## Appeal Decisions

### **Appeal A Ref: APP/R5510/X/24/3336736**

#### **51 Ickenham Road, Ruislip, Hillingdon HA4 7BZ**

### **Appeal B Ref: APP/R5510/W/24/3336533**

**Drawing Content:**  
Proposed Roof Plan

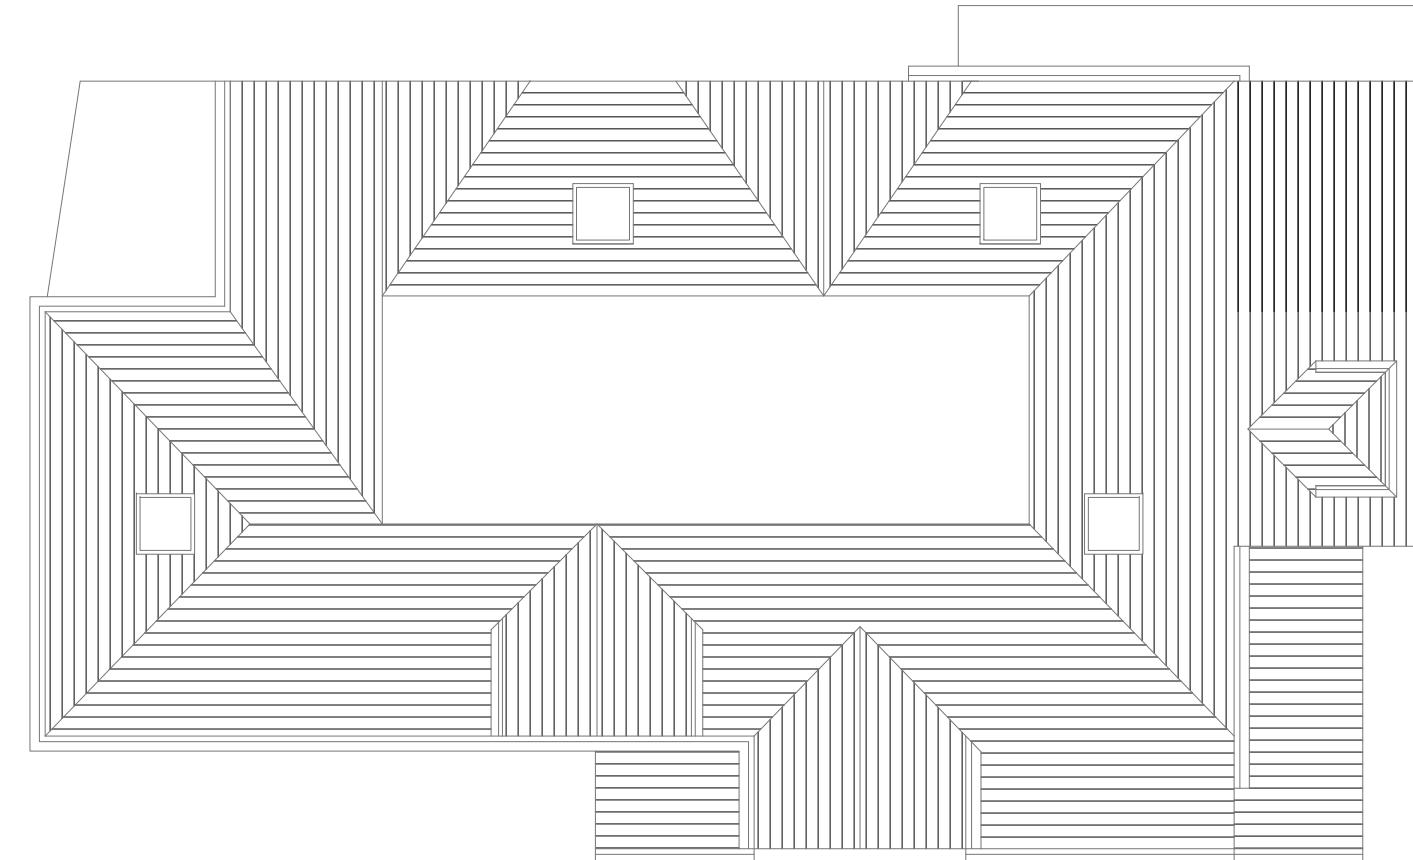
30. The appeal property has been extended and altered and at my site visit I noted that it appears that all its fenestration has been replaced. Nevertheless, the replacement of that fenestration does not form part of the proposal before me. That proposal relates to a first floor and loft extension above an existing single storey extension which forms one of the rear corners of the building. At first floor level it would extend the rear elevation of the dwelling out so that it would be equal with that of a previous rear extension. The catslide roof at the side of the dwelling would be extended over most of the single storey extension. As a result, the proposal would include the removal of the lantern and most of the flat roof over the single storey extension. However, given that it is a single storey extension the lantern and flat roof do not harm the character and appearance of the host dwelling.

31. The footprint of the extension would not be overly large when considered against the overall size of the dwelling. However, as the highest part of the proposed roof would match that of the existing building the existing crown roof would be extended sideways. That existing crown roof is currently visually contained in a central area of the roof, with sections of traditional ridge detailing on both sides of it. However, the extension of that crown roof would result in a significant increase to the bulk and massing of the appeal building at roof level. Moreover, it would mean that on this side of the dwelling the highest part of the roof would be formed by a crown roof rather than a traditional ridge detail.

33. The increase in bulk and massing and the visible extent of the crown roof would erode the original architectural quality of the host dwelling that is imparted by its hipped and pitched roof. Additionally, even though the materials would match that of the existing roof, the bulk and mass of the proposal would appear as a disproportionate addition to the host dwelling. As such its character and appearance would be harmed and its contribution to the character and appearance of the surrounding area would be materially diminished.
